DEPARTMENT OF PUBLIC WORKS

MEMORANDUM

TO: All Staff
FROM: Public Works Plan Review Team
DATE: July 15, 2024
SUBJECT: LP-24-00003 Suncadia Ph 2 Div 7

NELSON STREAM
PRELIMINARY PLAT

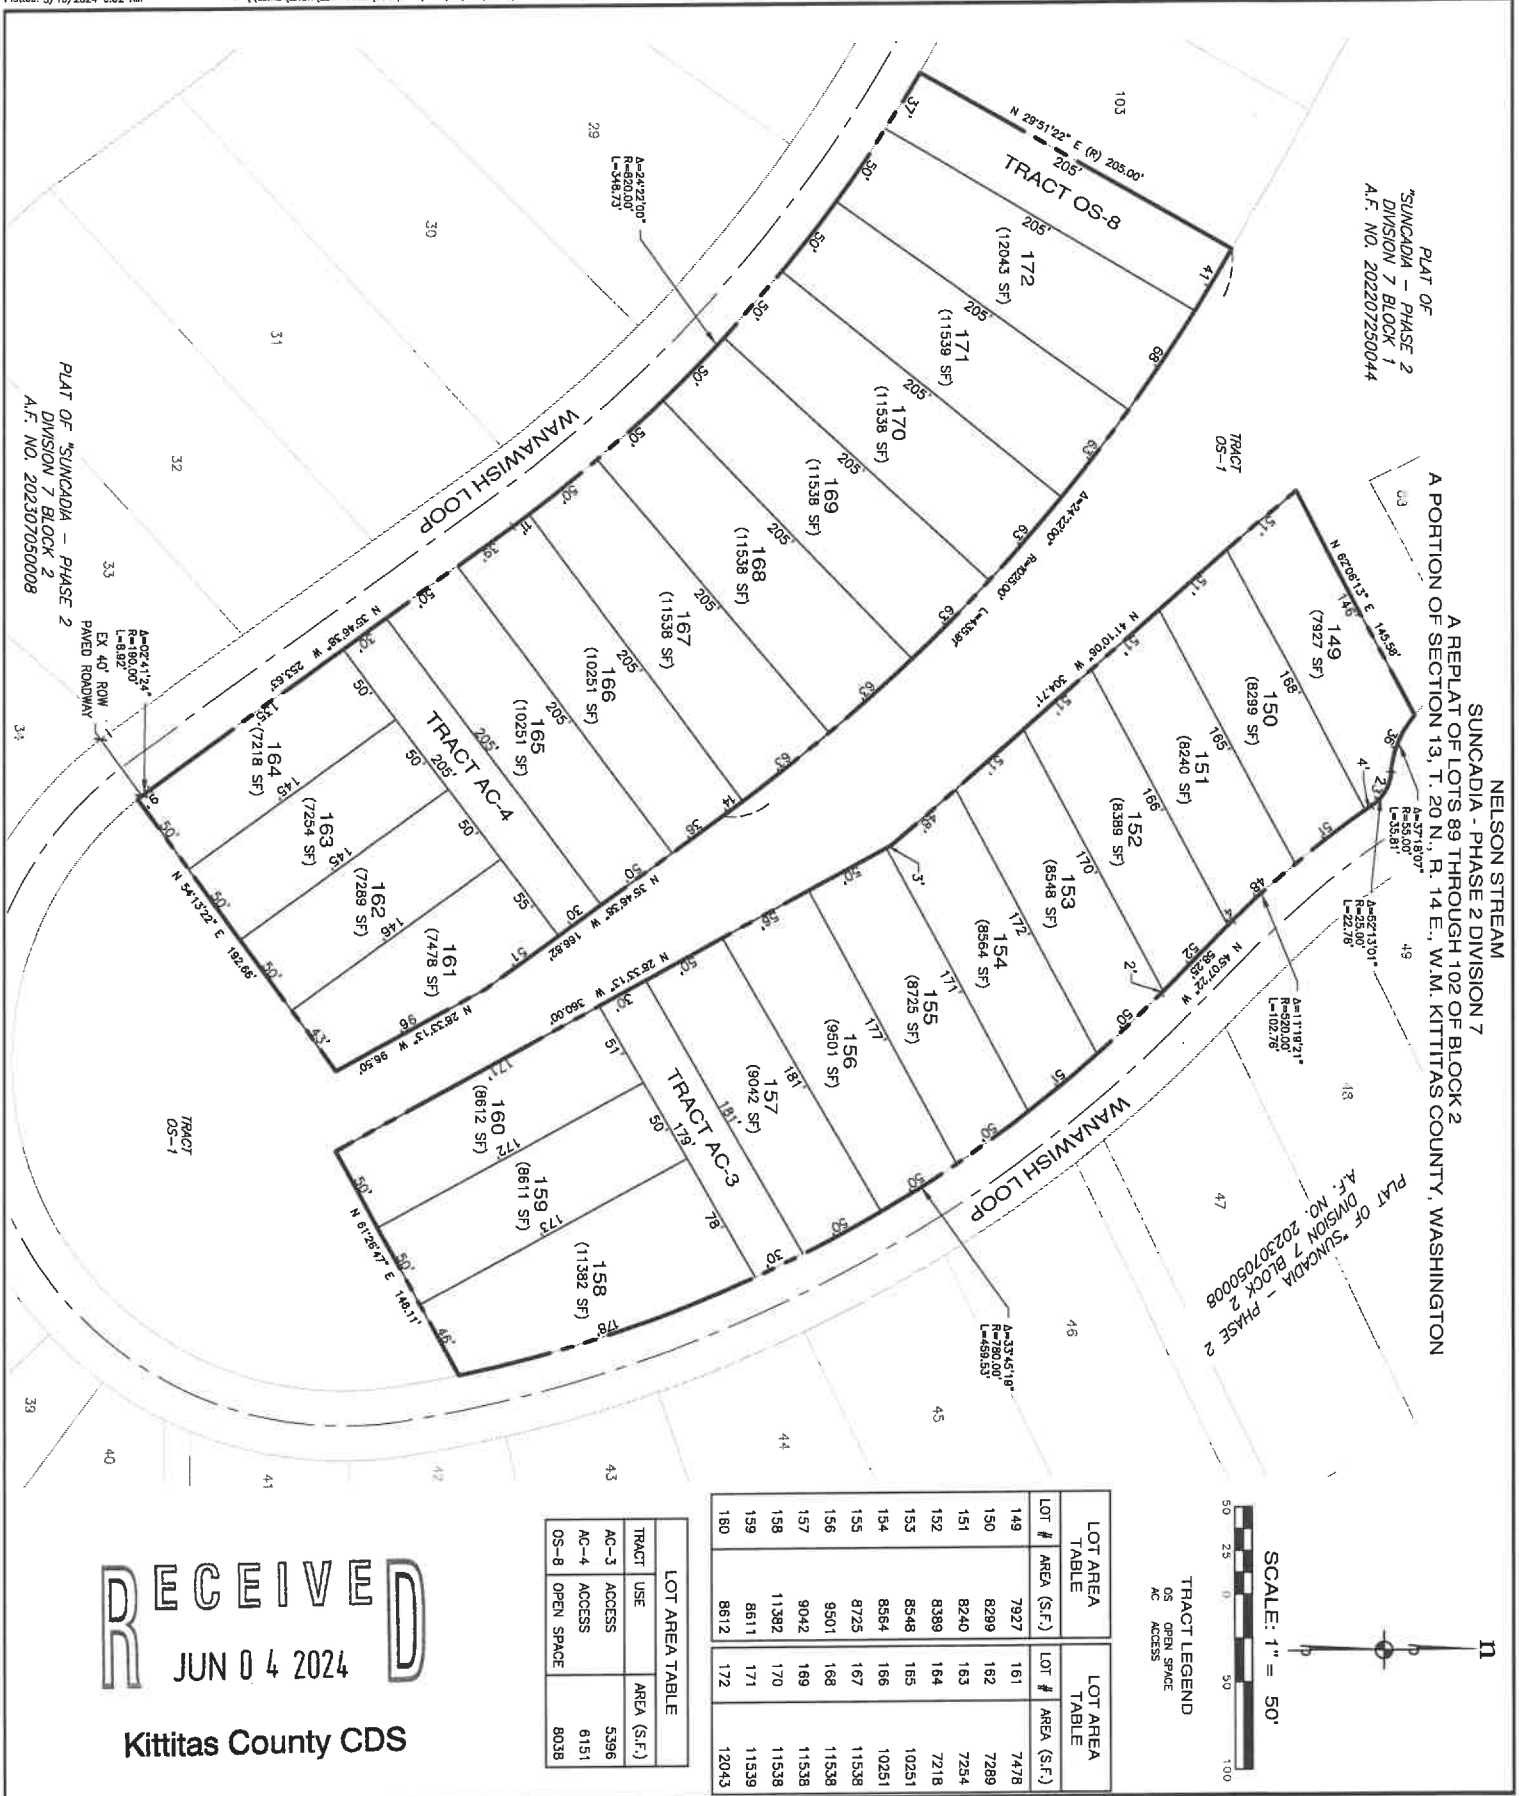
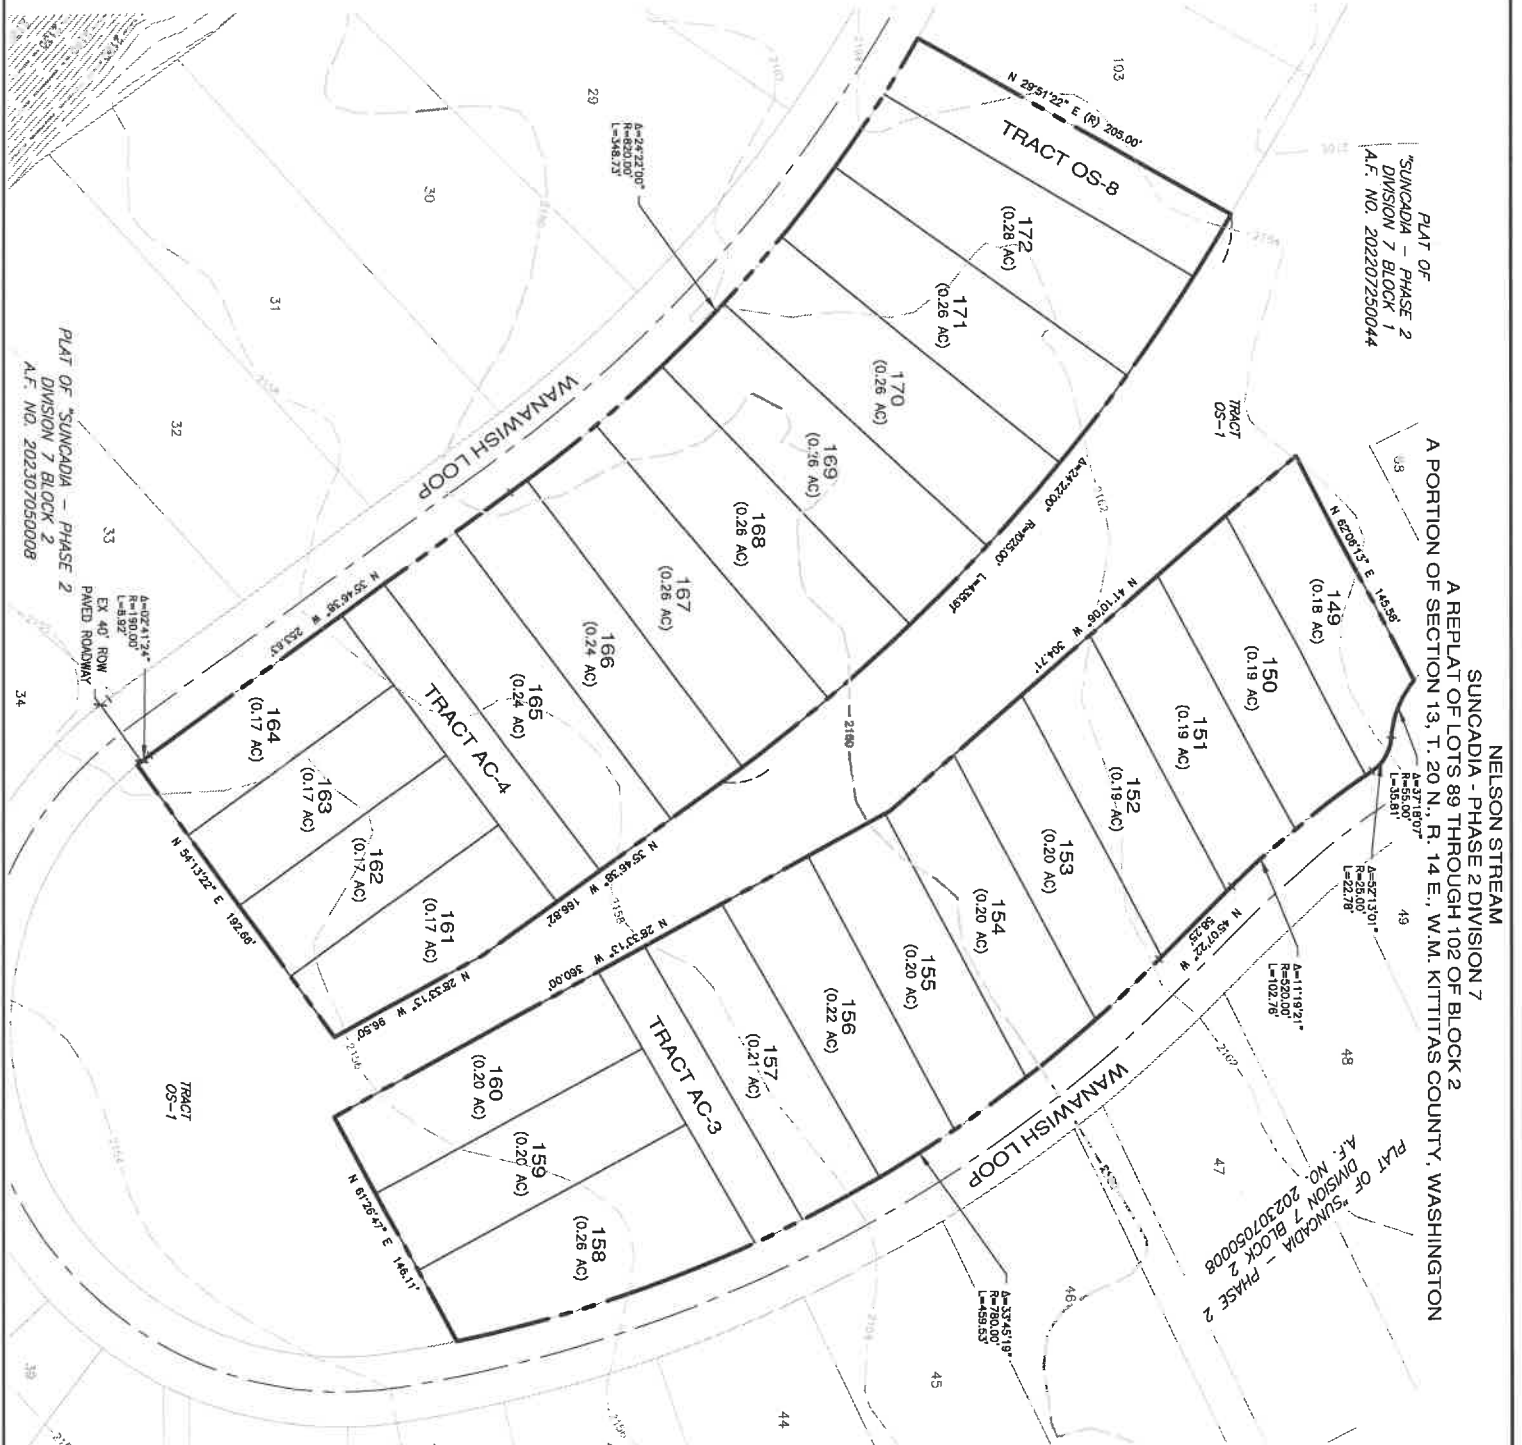
ACCESS	No comments. (JS)
ENGINEERING	<ol style="list-style-type: none">1. Please provide an inventory of equivalent residential units, or the accounting method utilized in the water system plan, affirming sufficient capacity serving the plat.2. Please provide an inventory of equivalent residential units, or the accounting method utilized in the general sewer plan, affirming sufficient capacity serving the plat.3. Public Works will reserve additional engineering comments for the Civil Review process. (CP)
SURVEY	<p>No additional survey requirements as part of the preliminary Long Plat.</p> <p>For final Long Plat, the following will need to be included:</p> <ol style="list-style-type: none">4. Controlling corners will need to be shown.5. As a minimum, corners between new division lines shall be set and shown on the face of the plat.6. Wanawish Loop shall be identified as being a "Private 40' Paved ROW". (JT)
